Recommendation Report for Planning Permission for Works or Extension to a Dwelling

REF NO: AW/109/21/HH

LOCATION: 3 West Avenue
Aldwick
PO21 3QN

PROPOSAL: Erection of a garage with adjacent utility room.

DRAWING
**PROPOSED
PLANS**
DRAWING No
347/03

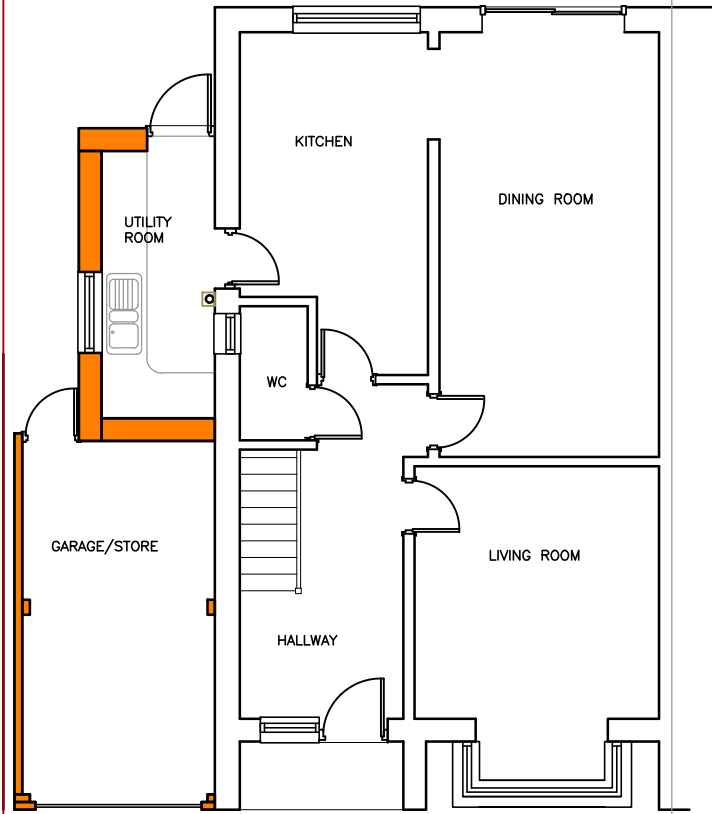
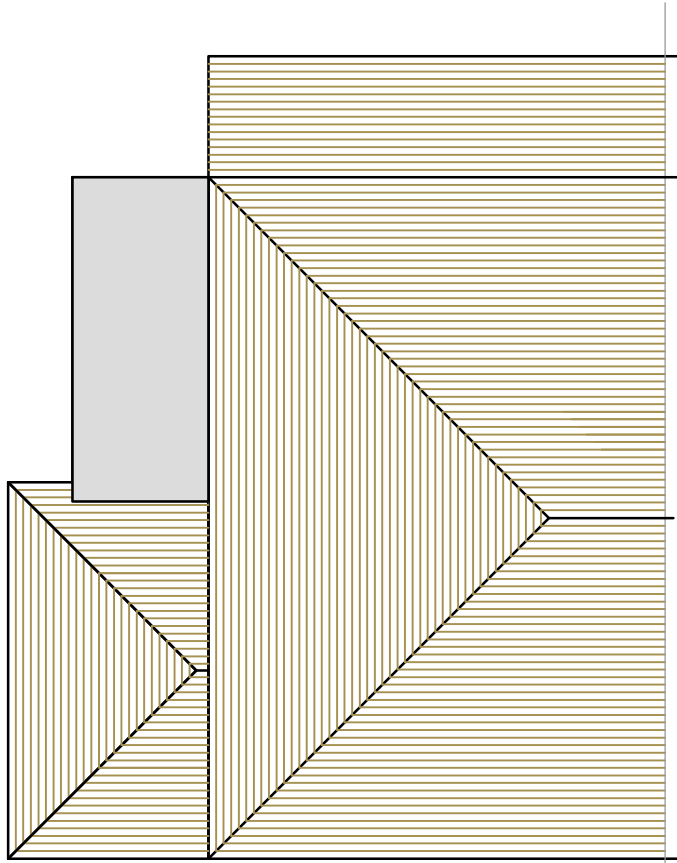
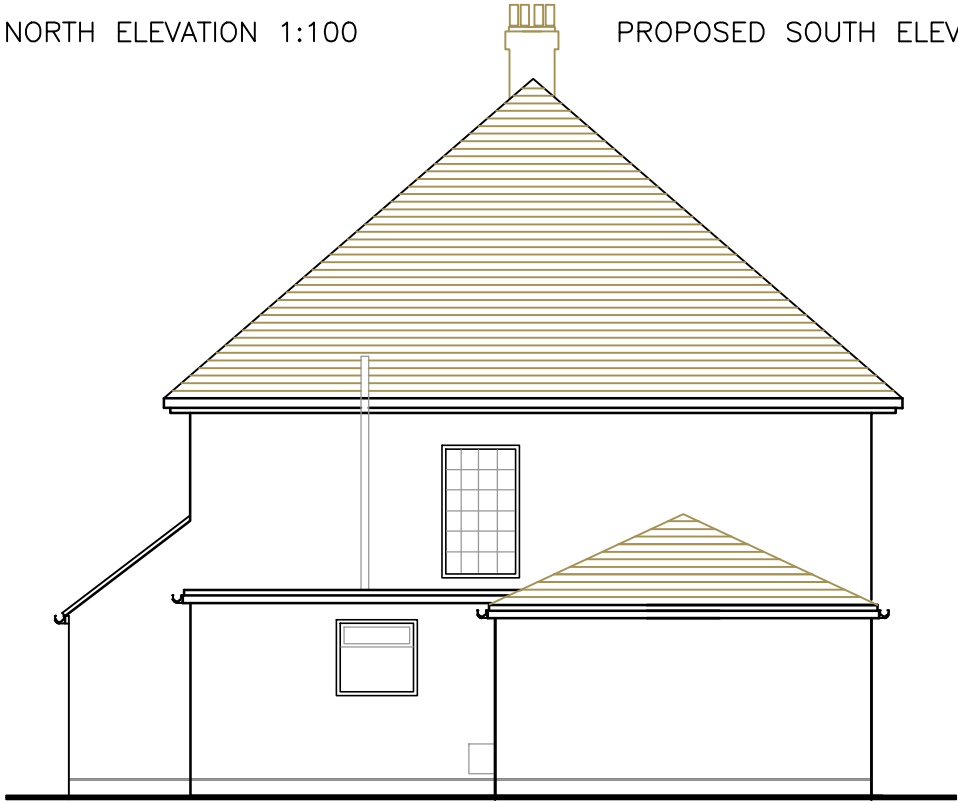
The proposal includes the erection of a single storey garage to the side of the dwelling. There will be a utility room added to the rear of the new garage. The garage extends along the boundary measuring 5m in depth and 2.5m at eaves height with a pitched roof height of 3.75m.

Arun recently adopted a Design Guide. It states development should be subservient to the main dwelling and this complies in terms of scale and size. Whilst the development is located within 1m of the boundary does not comply, due to the proposal being at single storey it is deemed acceptable.

The site is a semi-detached dwelling with 4.8m to the front and 18m to the rear boundary and the proposal does not have impact on the residential amenities of the surrounding dwellings. Whilst there is an opening for the utility room on the ground floor which will face the neighbouring boundary the views from which will not overlook the neighbouring property due to the single storey nature of the proposal.
